Application no: 23/01031/DISC

Location: Axis J9 Phase 3, Howes Lane, Bicester

Transport Development Control

This application is to discharge condition 6 for the footway/cycleway link between the site and Howes Lane. The path will link to a new toucan crossing on Howes Lane, which is the subject of a S278 application to OCC, whereby the detail will be agreed.

NOTES

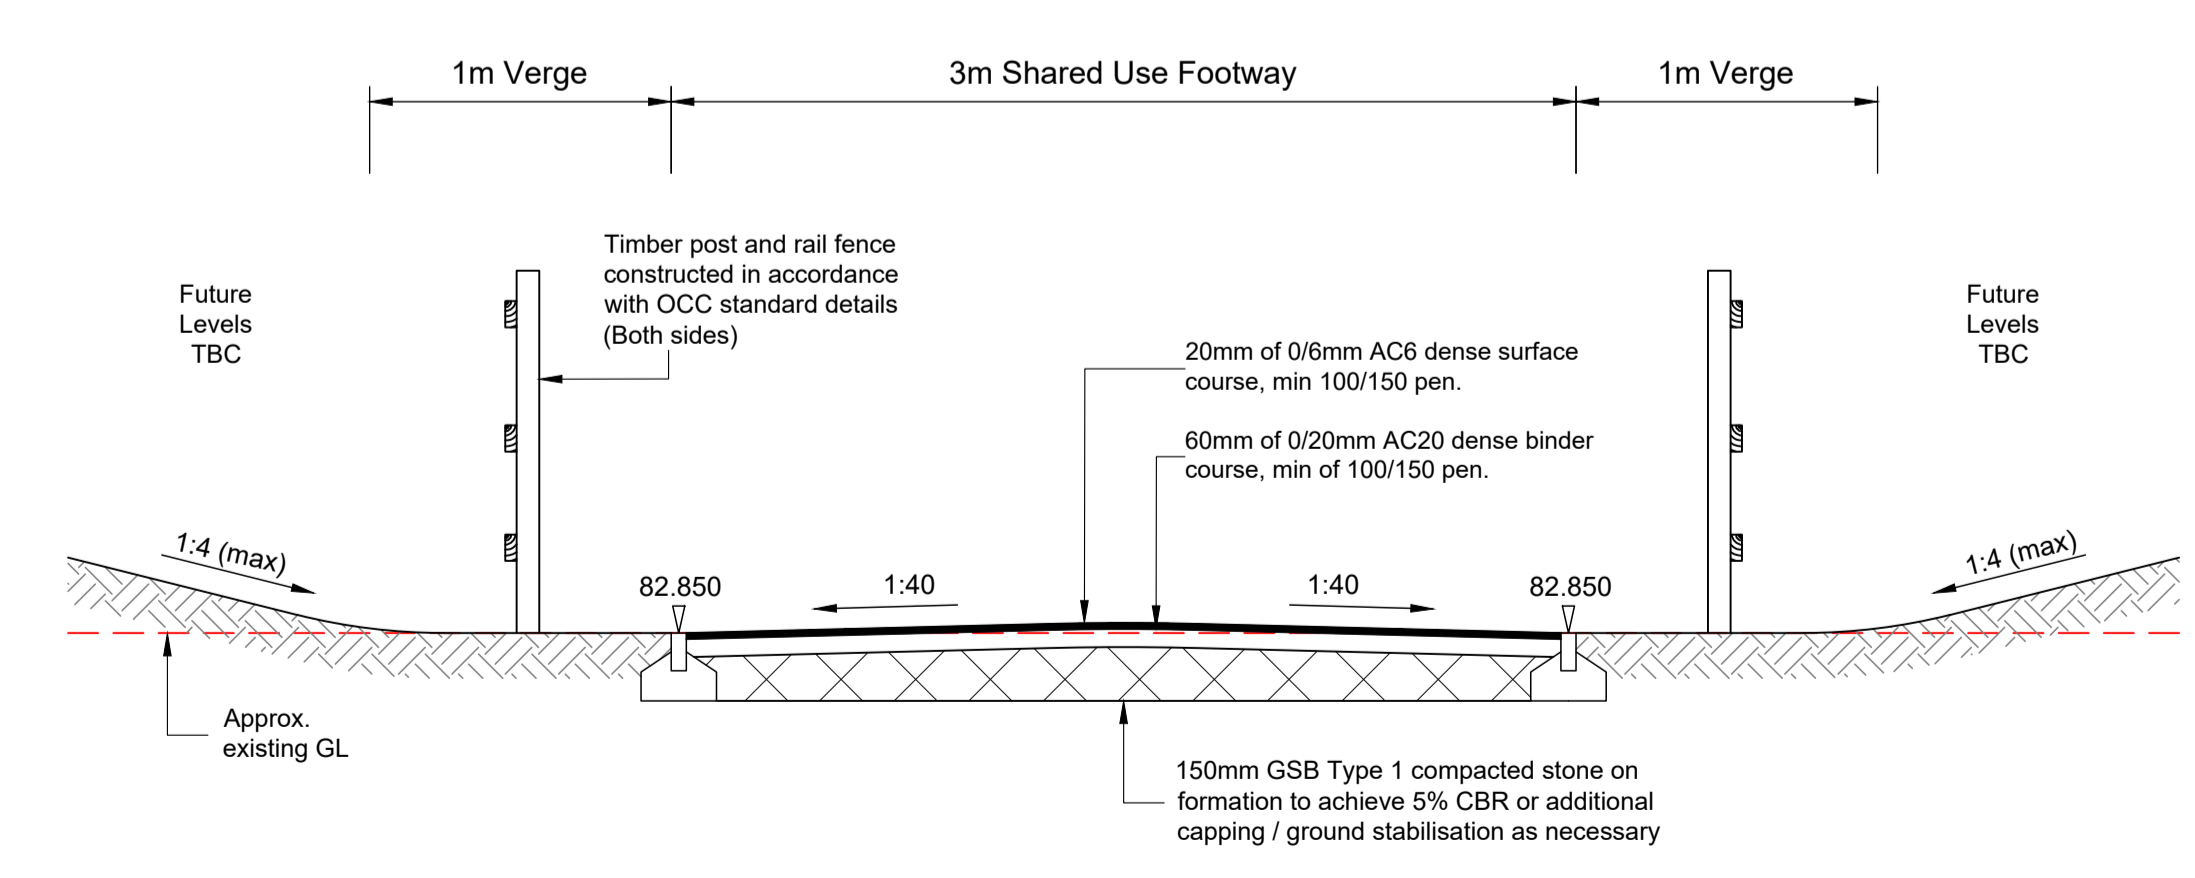
It's assumed that this path will be part of a S38 submission, whereby the technical detail will be agreed. However, it is acceptable in principle. The path is proposed as a 3m wide shared use path, which is in line with the planning permission and acceptable here as in the longer term the path will have a relatively low level of usage, the main route being provided via the paths alongside the new strategic link road.
